**From:** Holly Myers  
**Sent:** Tuesday, December 23, 2014 11:10 AM  
**To:** Kaycee Hathaway  
**Cc:** Erin Moore  
**Subject:** McDonald CU-14-00005

We need clarification for his long term water use proposal. Creating a program based on when and if KRD is cleaner and the use is accepted is not a long term plan.

Drawing file: CU-14-00005 McDonald / CU-14-00005 McDonald Site Plan.pdf

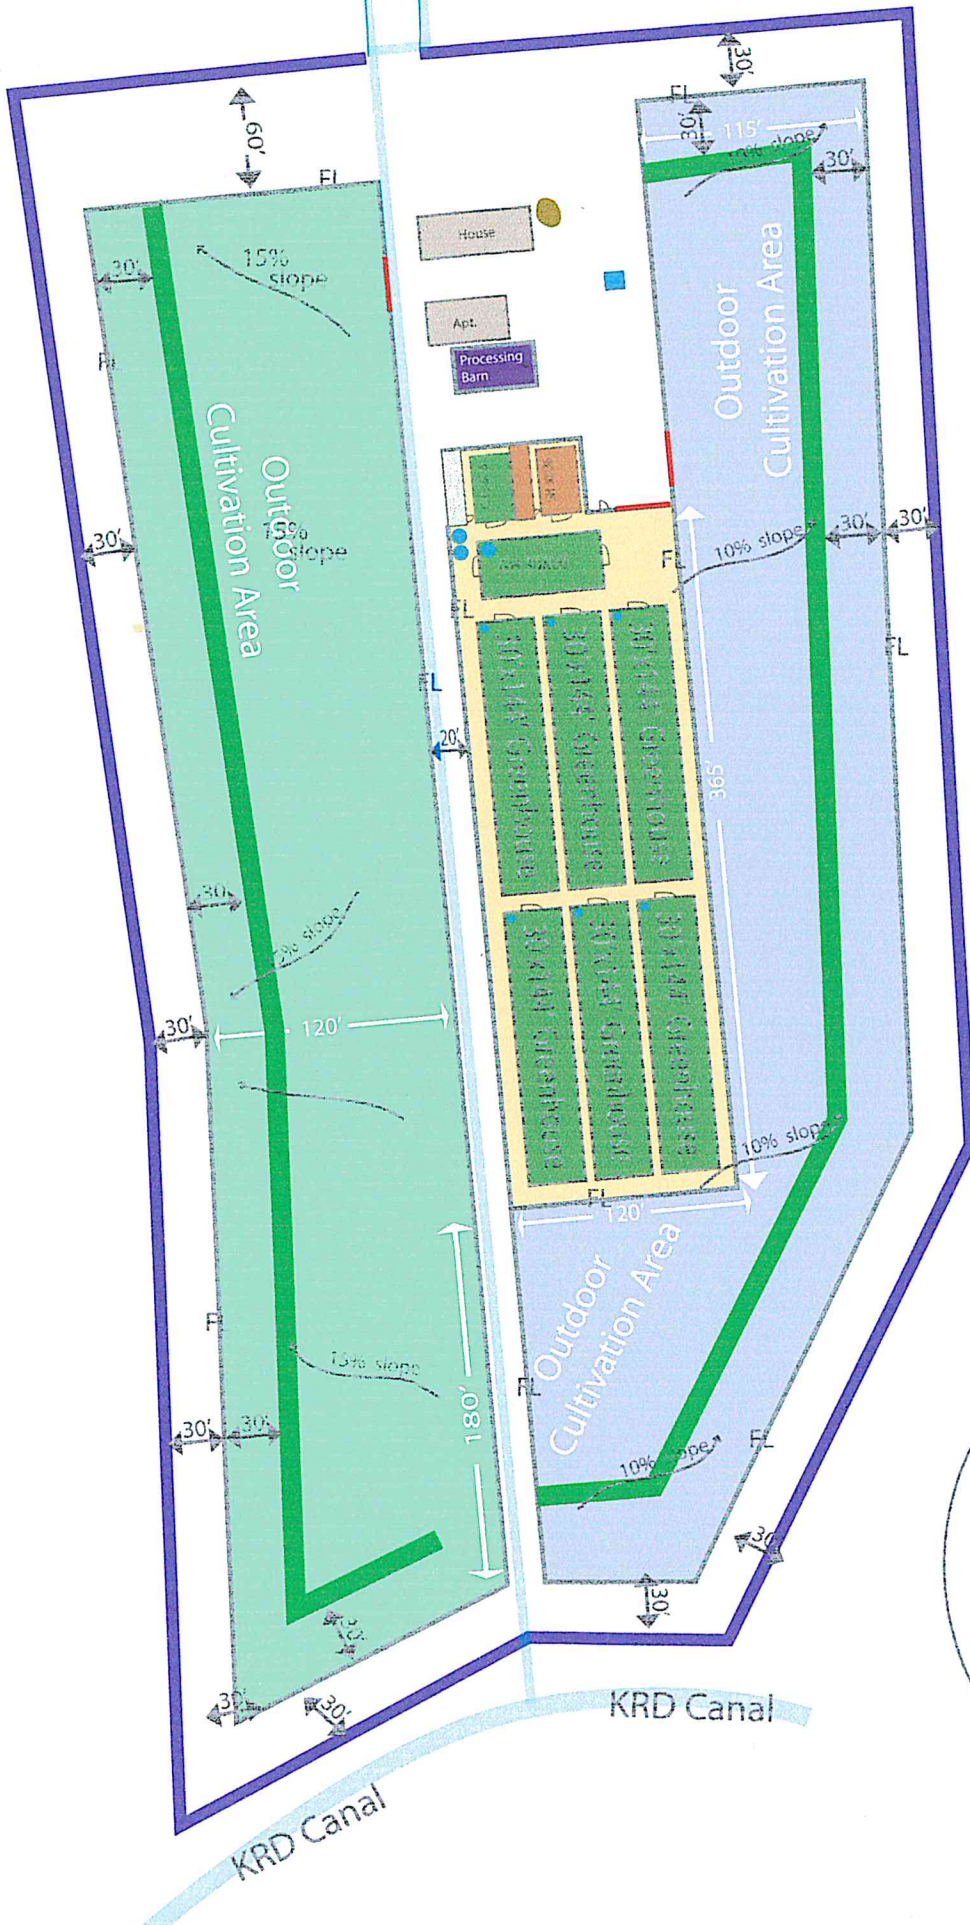
WE also need clarification on the sewage disposal methods as controlled burning is not an acceptable method of sewage disposal or solid waste disposal for organic material.
